From: Martyn White <Martyn.White@arun.gov.uk> **On Behalf Of** Conservation Officer
Sent: 16 June 2026 17:19
To: Planning.Responses <Planning.Responses@arun.gov.uk>
Cc: Harry Chalk <Harry.Chalk@arun.gov.uk>
Subject: LU/102/26/L

LU/102/26/L

Address: Court Wick Park Courtwick Lane Littlehampton BN17 7PD

Proposal: Listed building consent for internal and external alterations to building to facilitate conversion and change of use to a children's care home, reinforcement of brick and flint garden wall with buttresses and reconsolidate wall with coping courses.

This drawing is the copyright of Manorwood Construction Ltd but may be used for planning purposes by the Local Authority without breach of copyright.

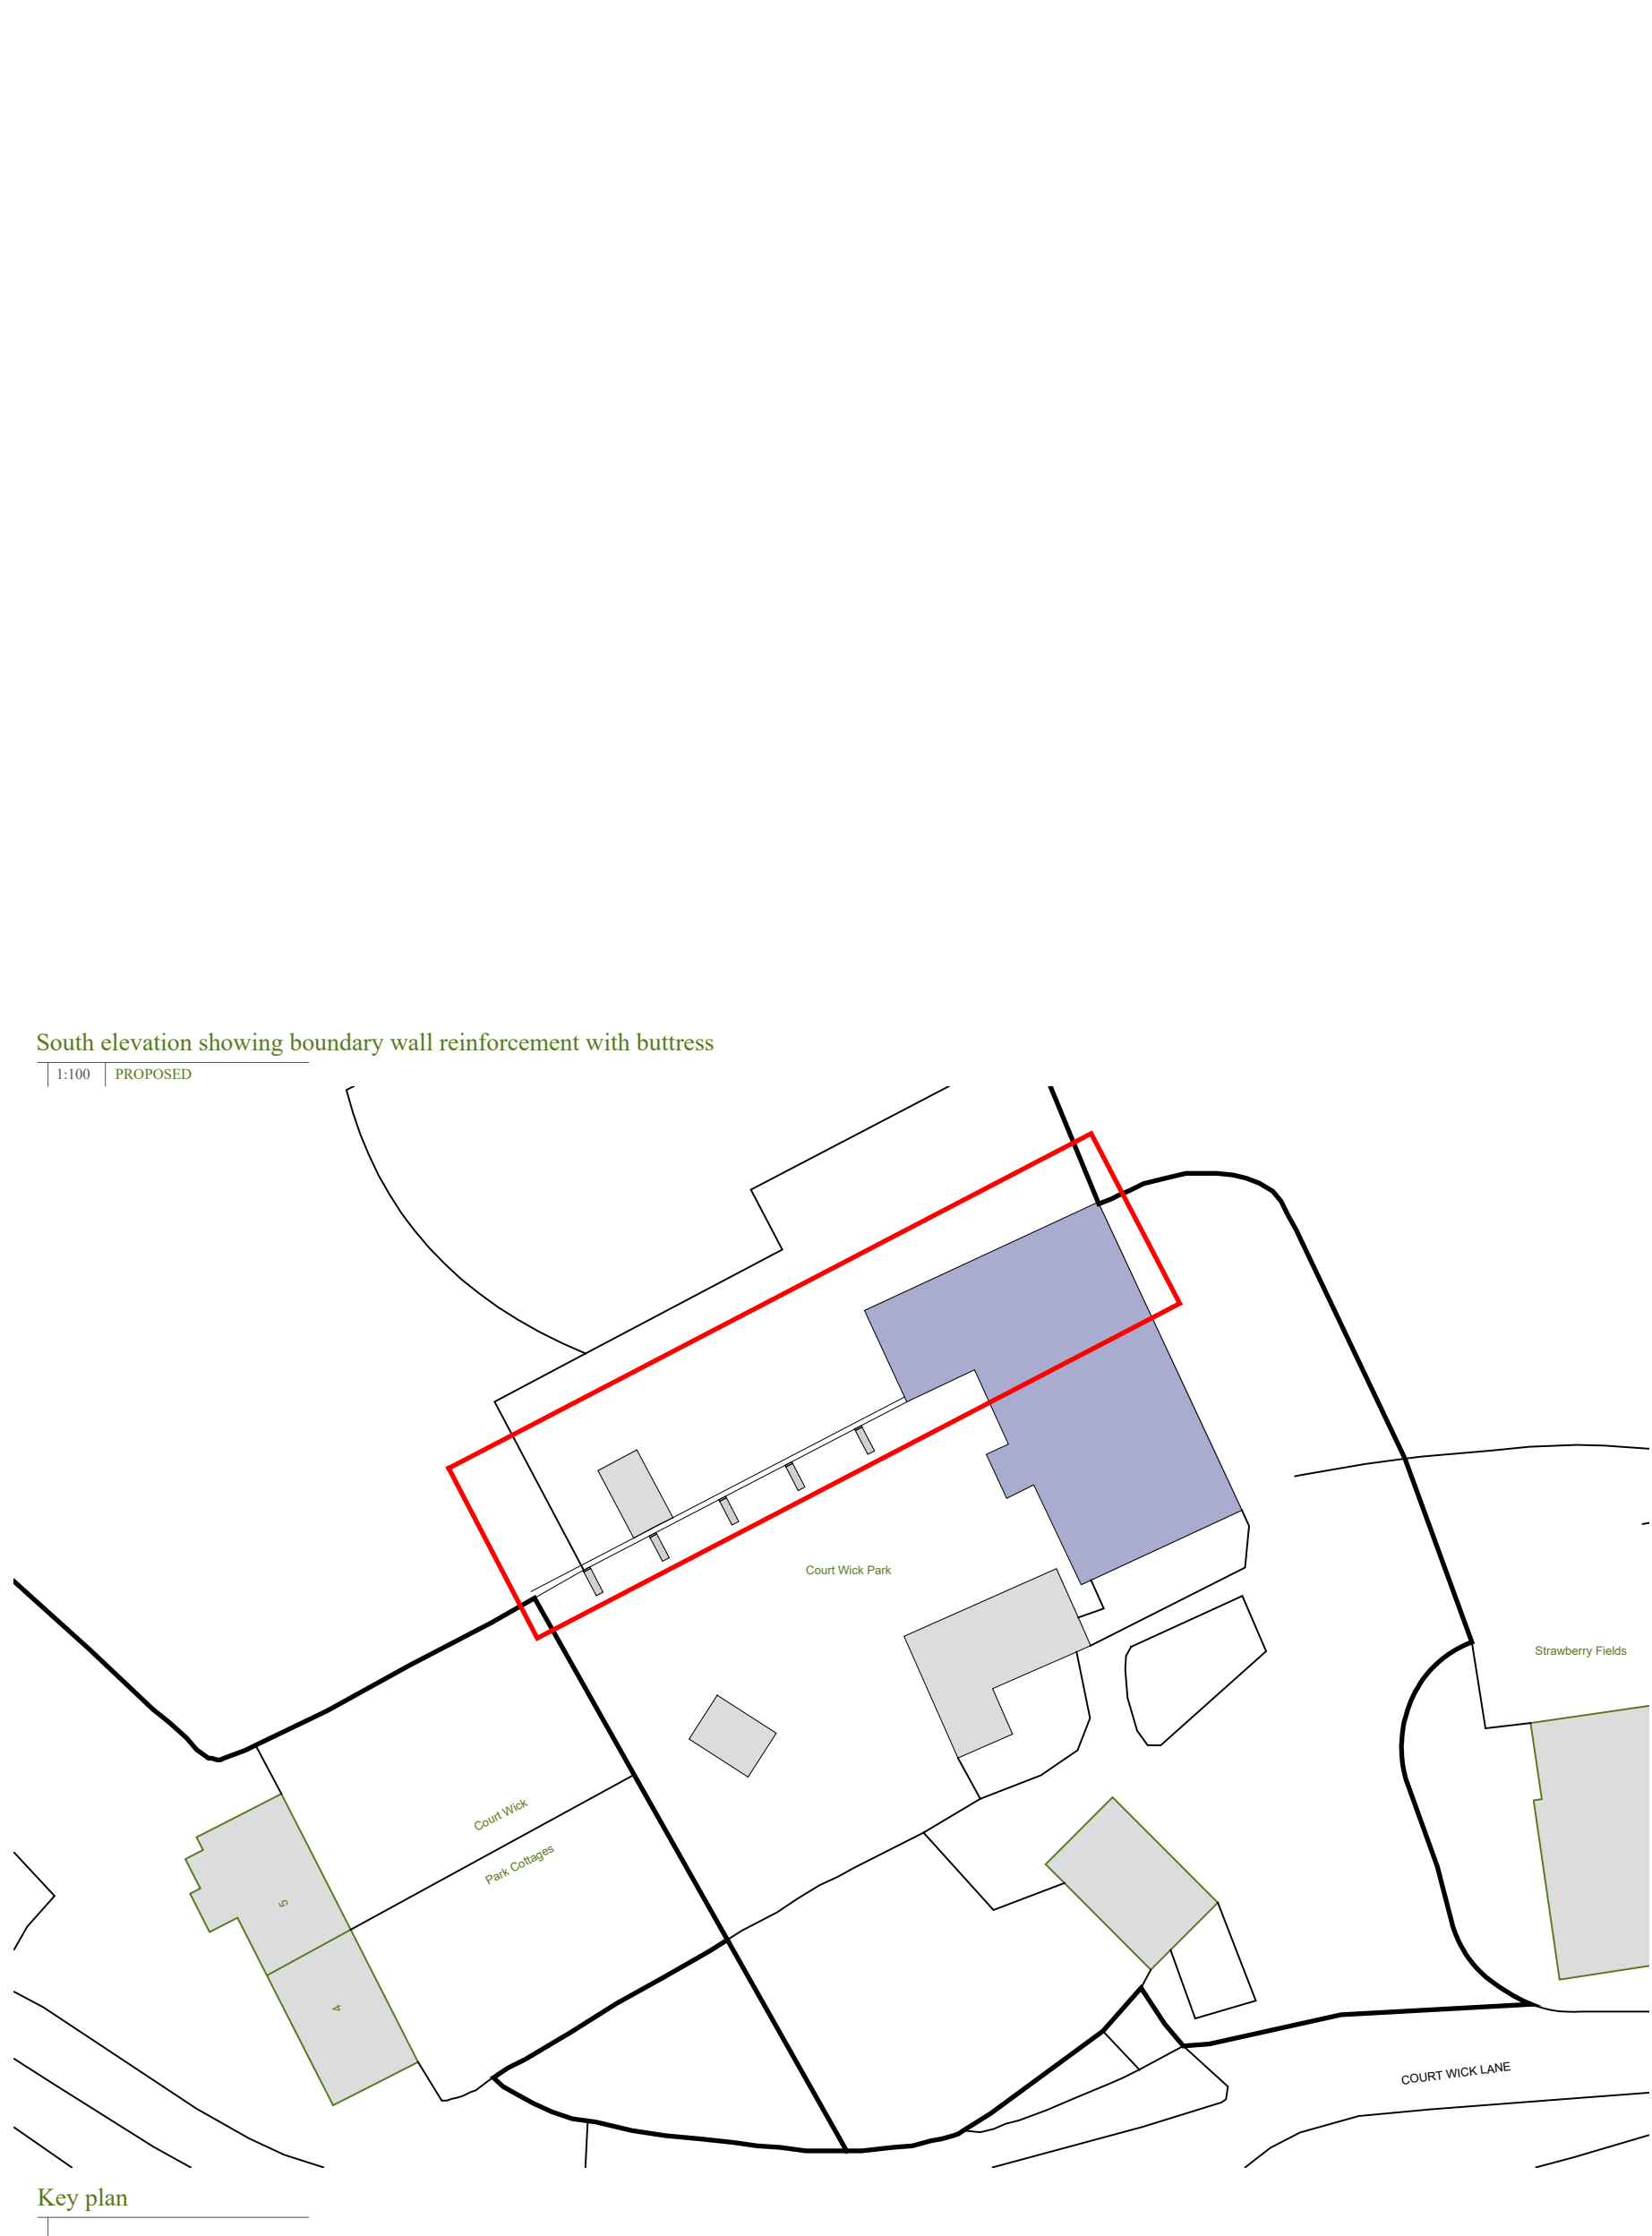
The existing flint and brick wall to the west of the building is clearly of significance and makes a positive contribution to the character of the site. Its retention is therefore essential. It is acknowledged that a number of repair and protection options have been considered, and the proposed approach appears to represent the least harmful intervention to the historic fabric and is therefore acceptable.

Drawing First Floor Plan

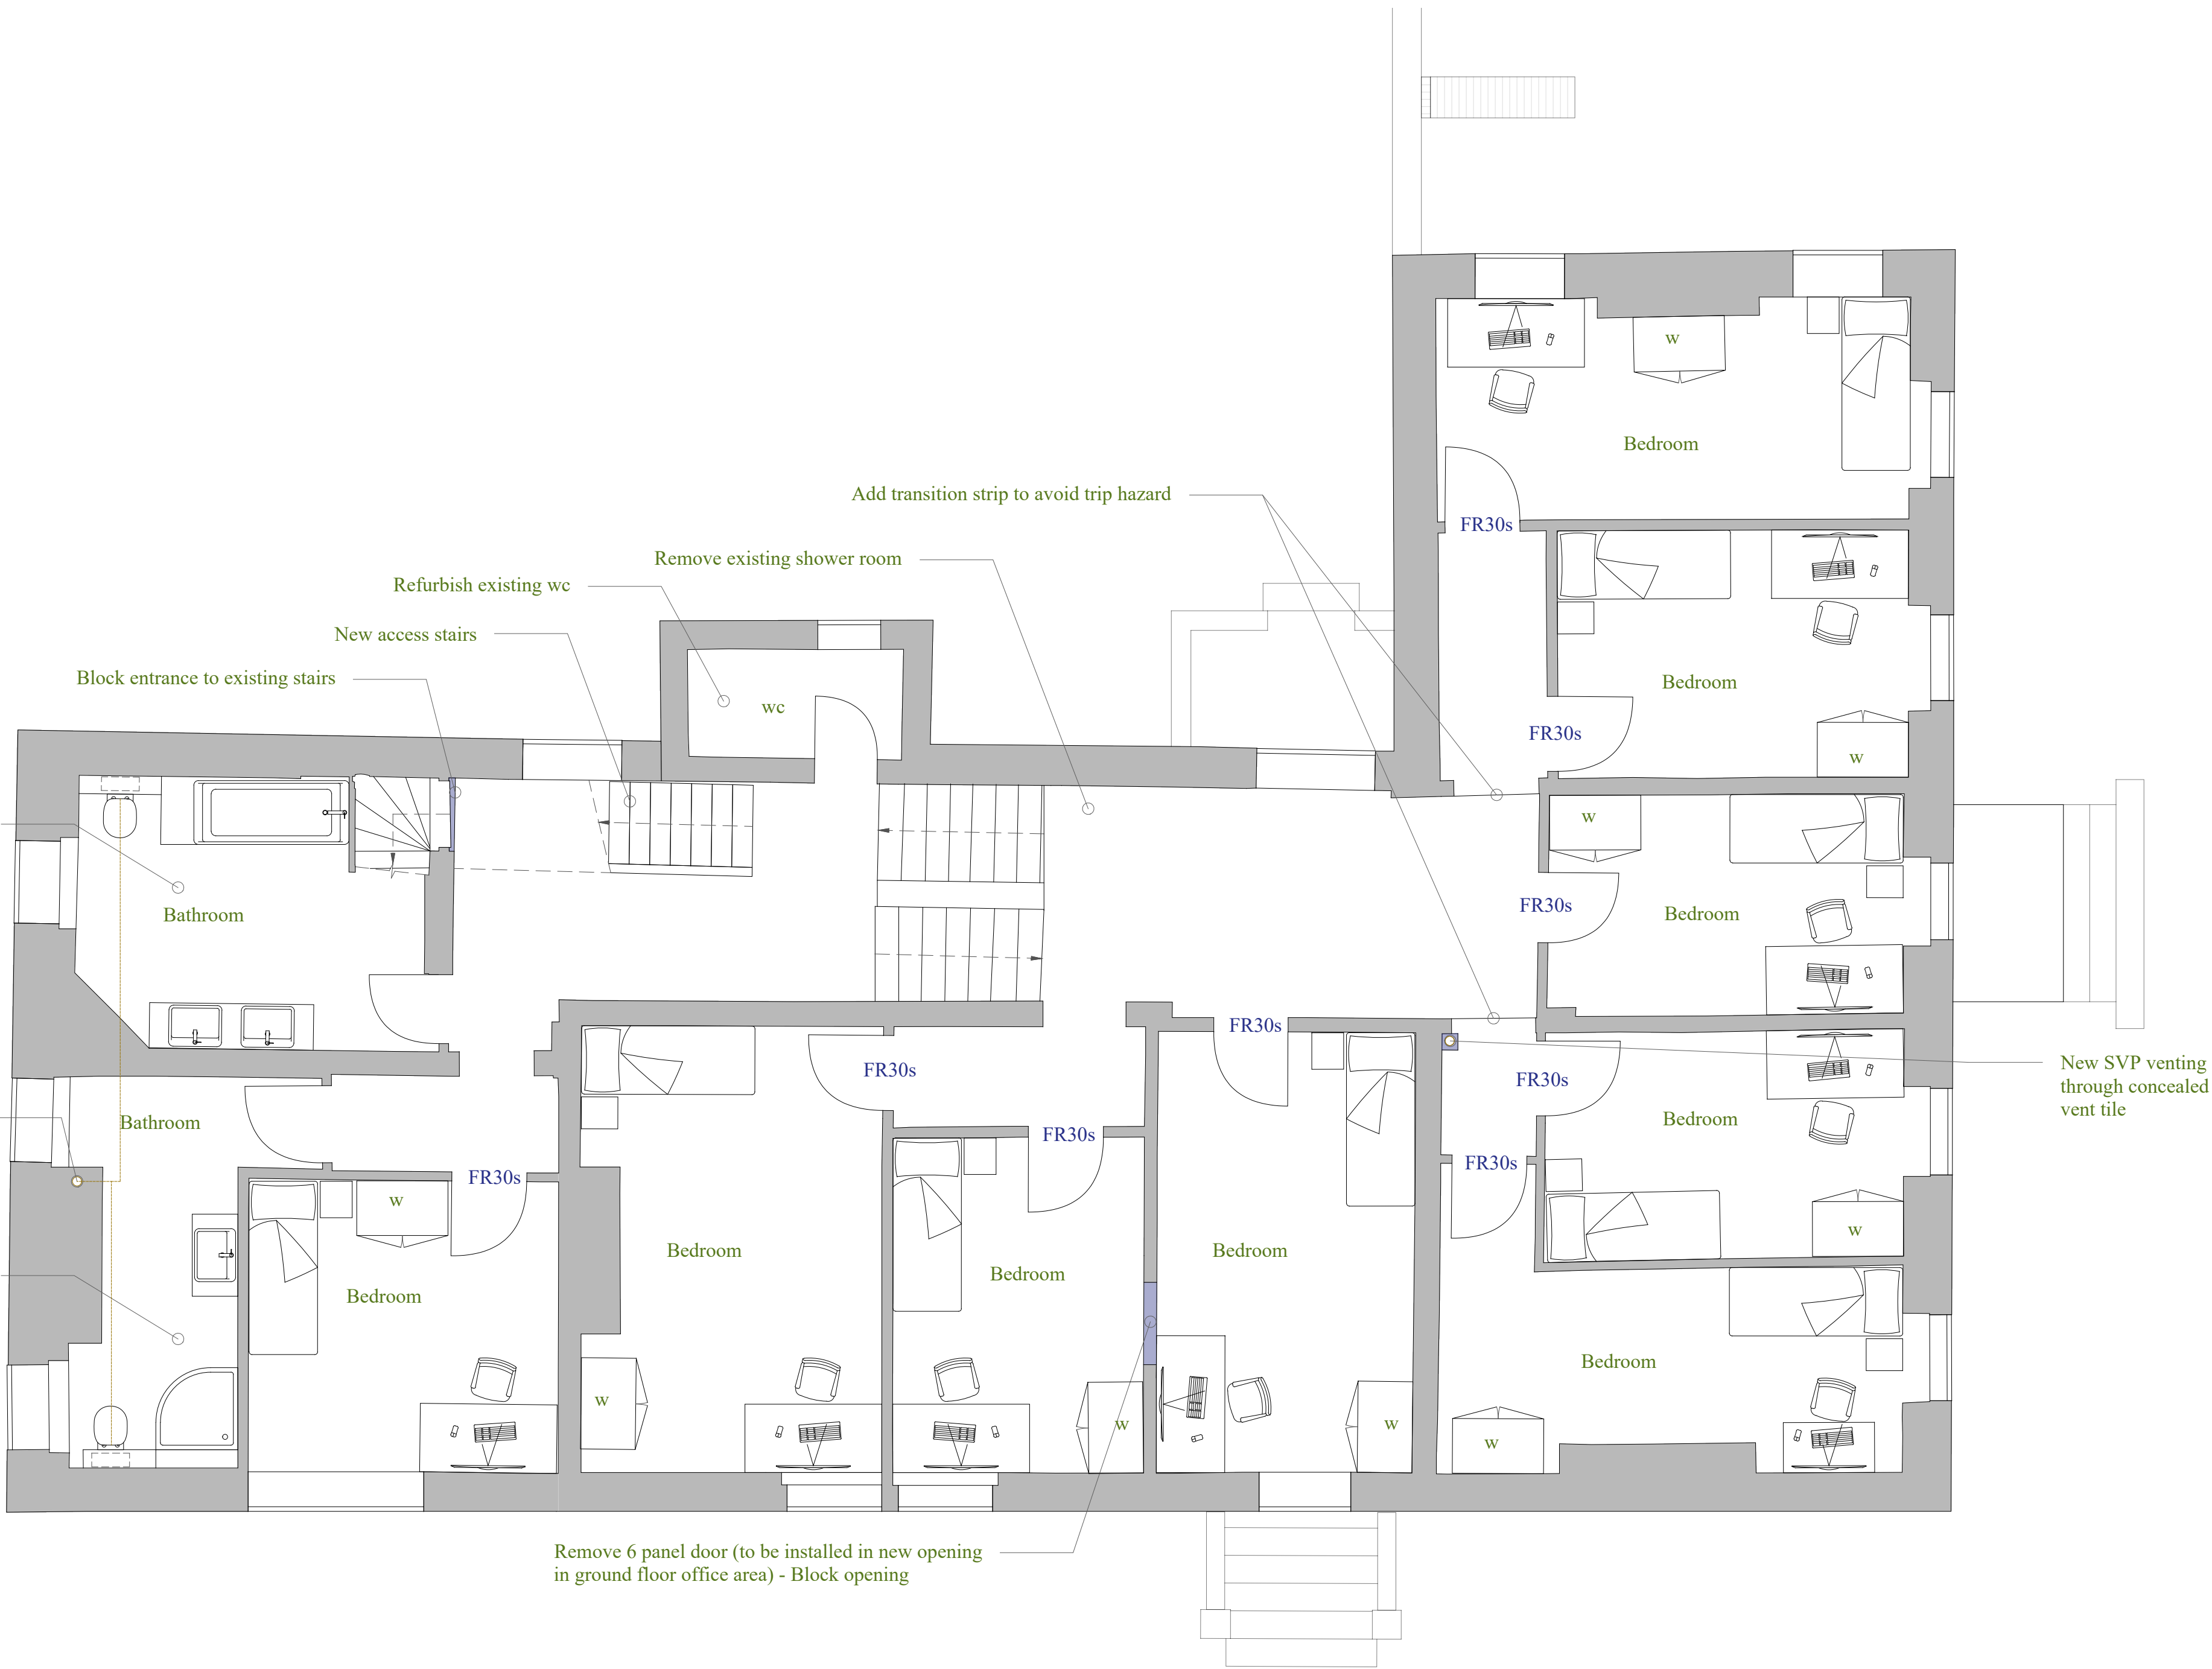
The introduction of a new staircase would result in the loss of a small section of ceiling fabric; however, this intervention would allow the existing original staircase to be retained in situ, which is supported.

Drawing West

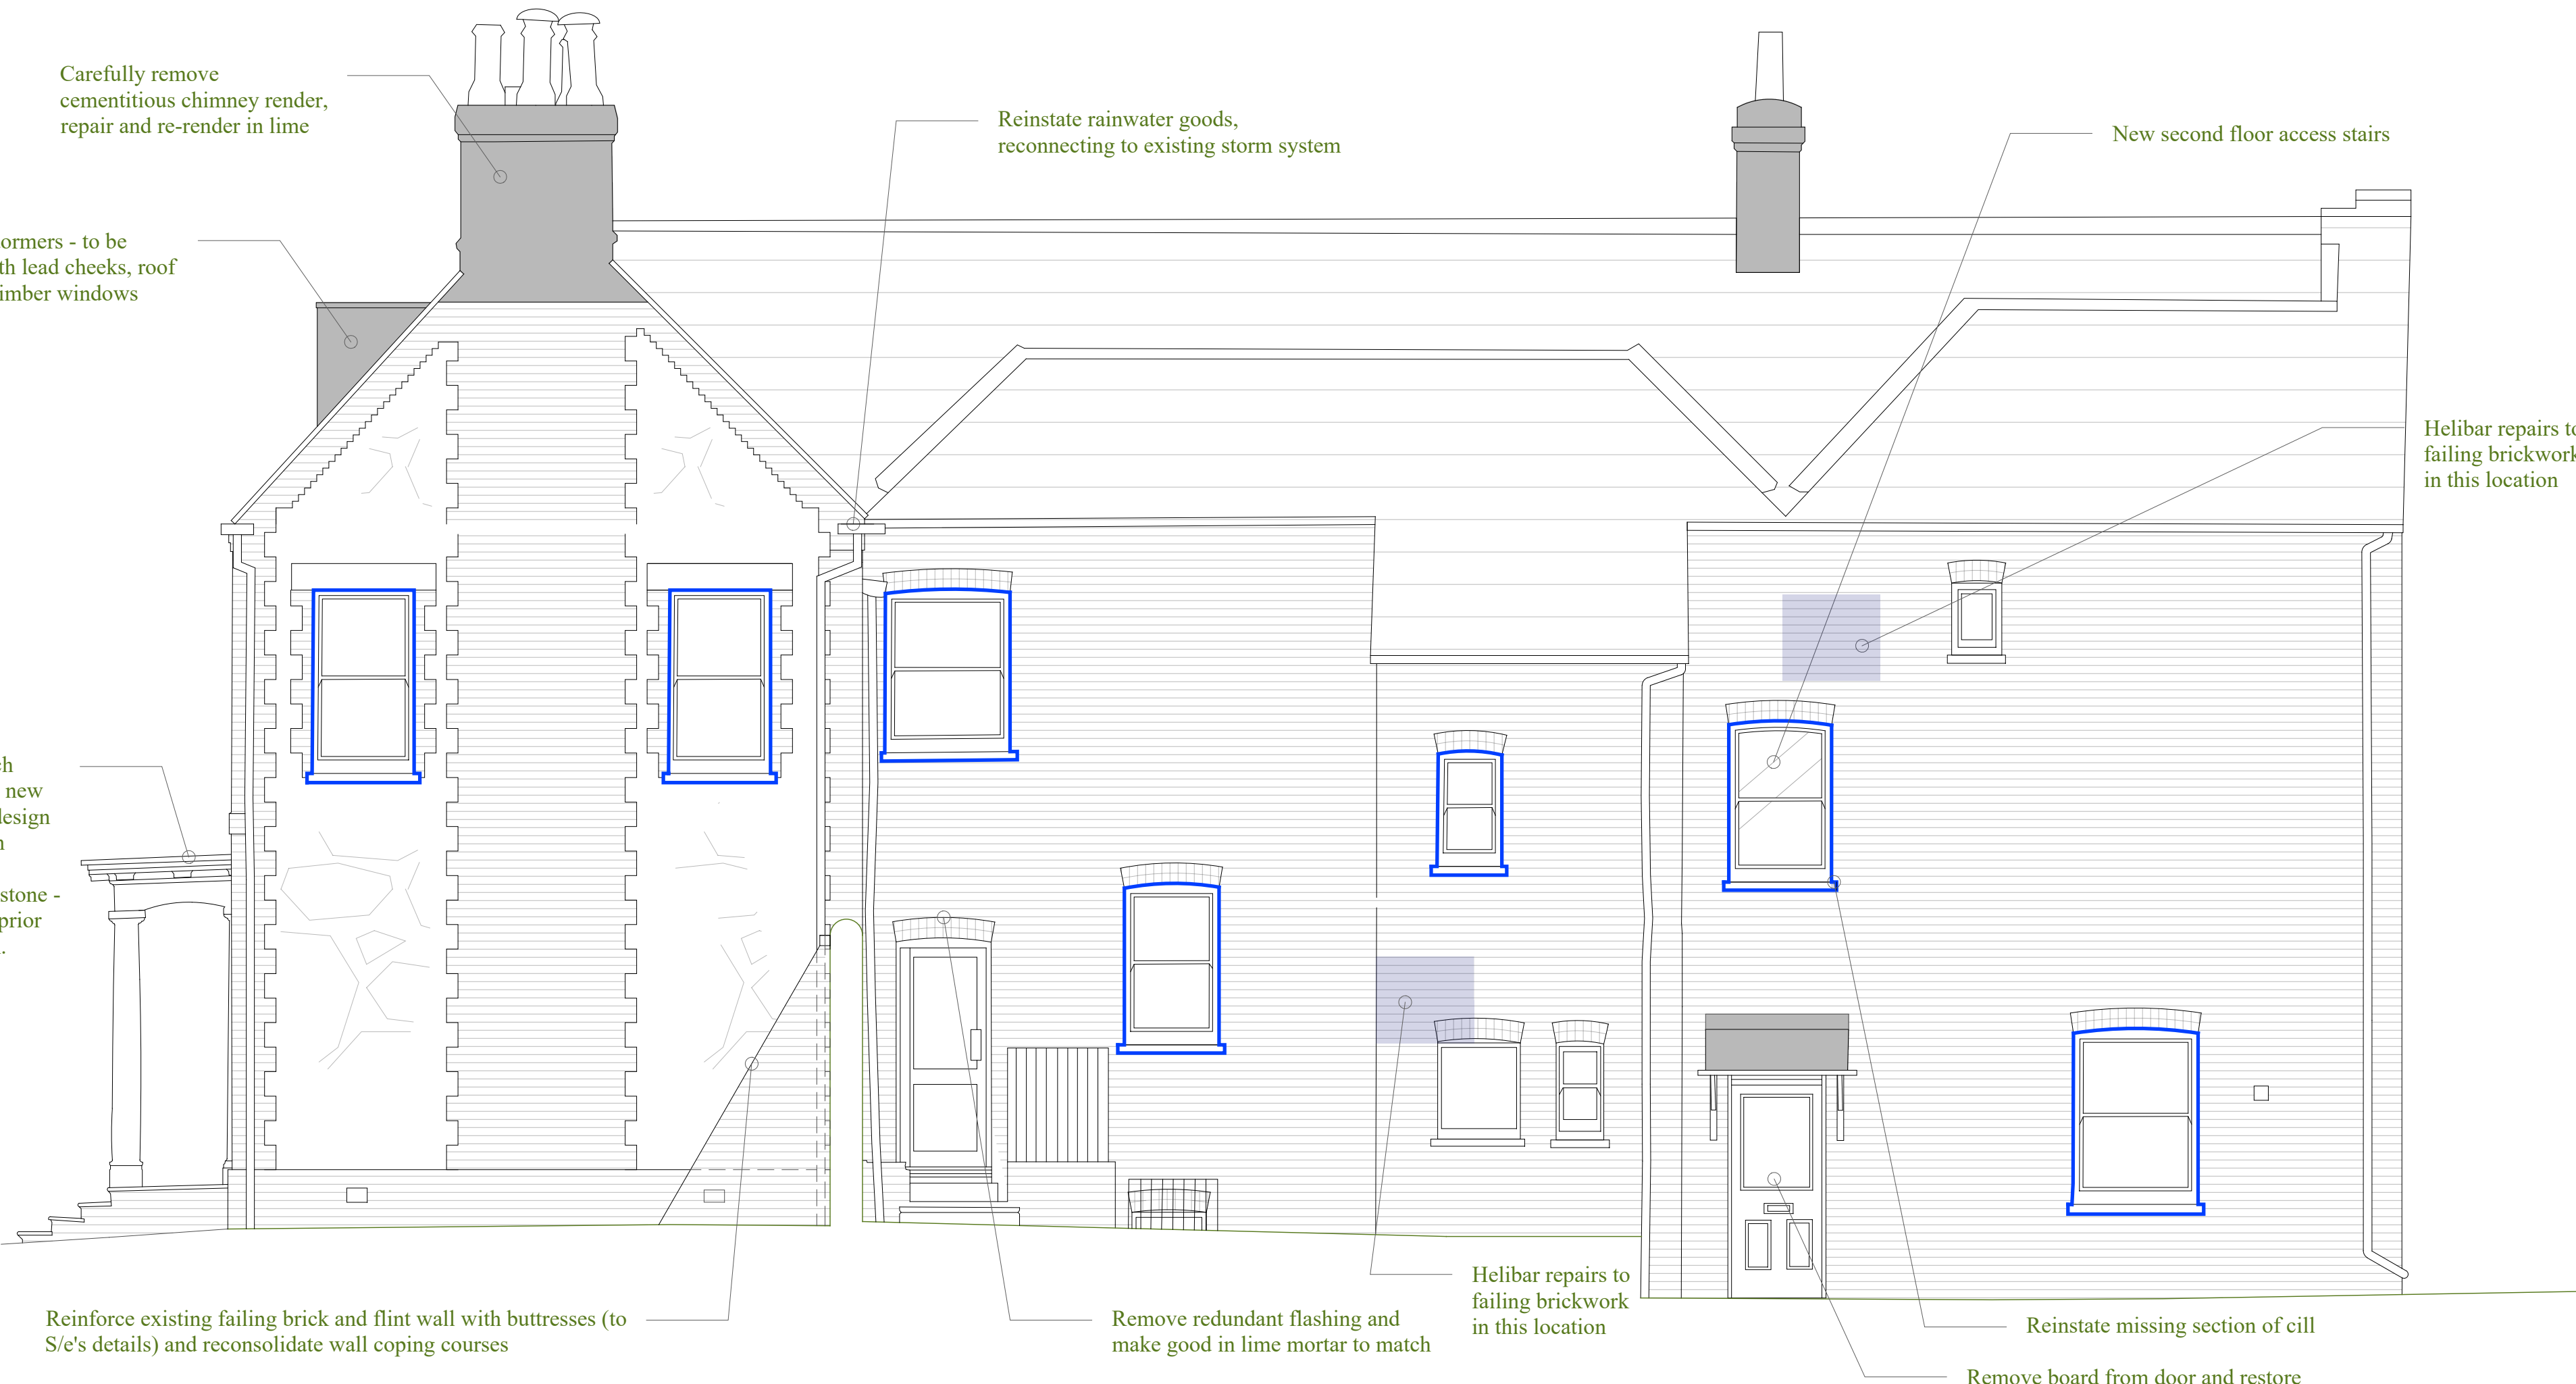
Whilst the external works are generally positive, it is disappointing to note the intention to replace the existing uPVC windows with new uPVC units. Reference is made to an alleged agreement to uPVC windows at a meeting; however, I do not recall this and would not support the use of uPVC within the historic environment, particularly within a listed building. The continued use of such windows is considered harmful to the significance of the heritage asset and cannot be supported. The windows should instead be replaced with appropriate timber equivalents, and the submitted drawings amended accordingly.

Whilst the majority of the proposal is acceptable, the use of UPVC windows cannot be supported and need to be removed in order for a no harm opinion form a heritage perspective.
